**Consultation Response from KC,
Lead Local Flood Authority**

2023/93783 Batteyford Playing Fields, Huddersfield Road, Mirfield, WF14 0EE

**Use of land for siting of five storage containers, erection of drying room, recreational space
and associated car parking**

Date Responded: 4th March 2024

PROPOSED SITE PLAN

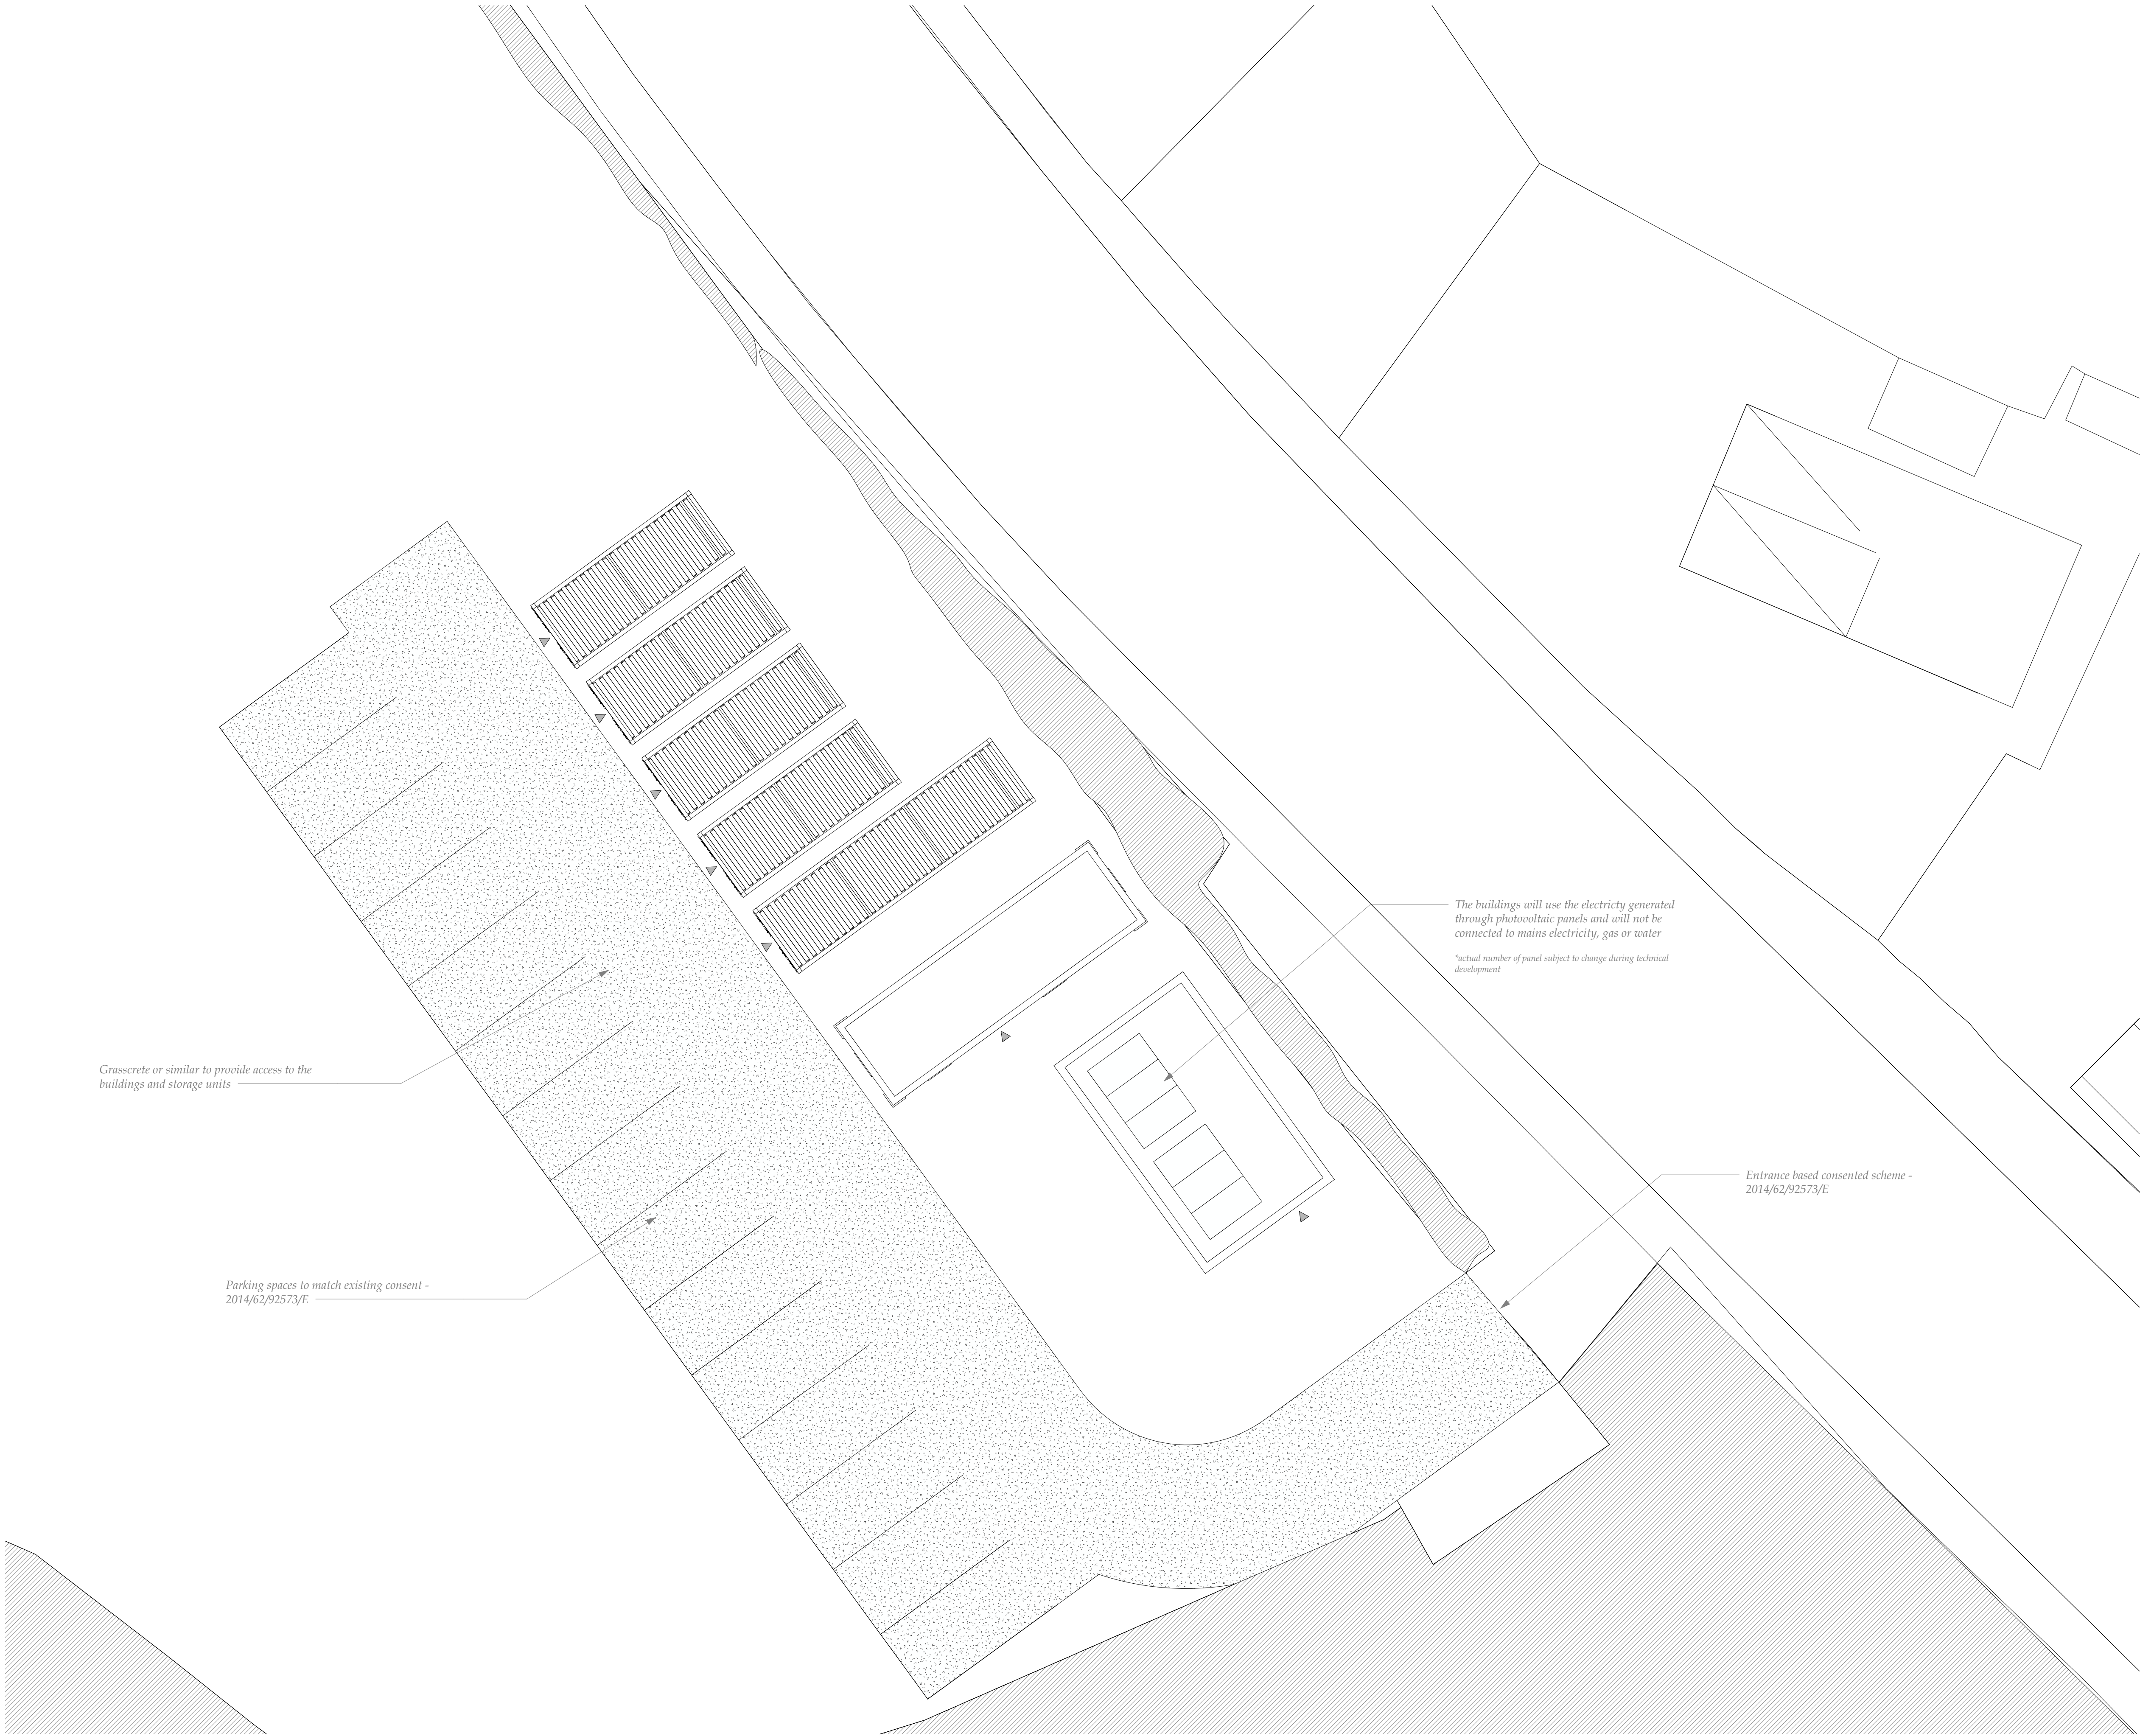
Kirklees Flood Management & Drainage acting as Lead Local Flood Authority OBJECTS to this application on POLICY GROUNDS.

The proposed development is in flood zone 3b – FUNCTIONAL FLOODPLAIN

Only 'water compatible' uses and essential infrastructure can be considered in this zone, in accordance with NPPF.
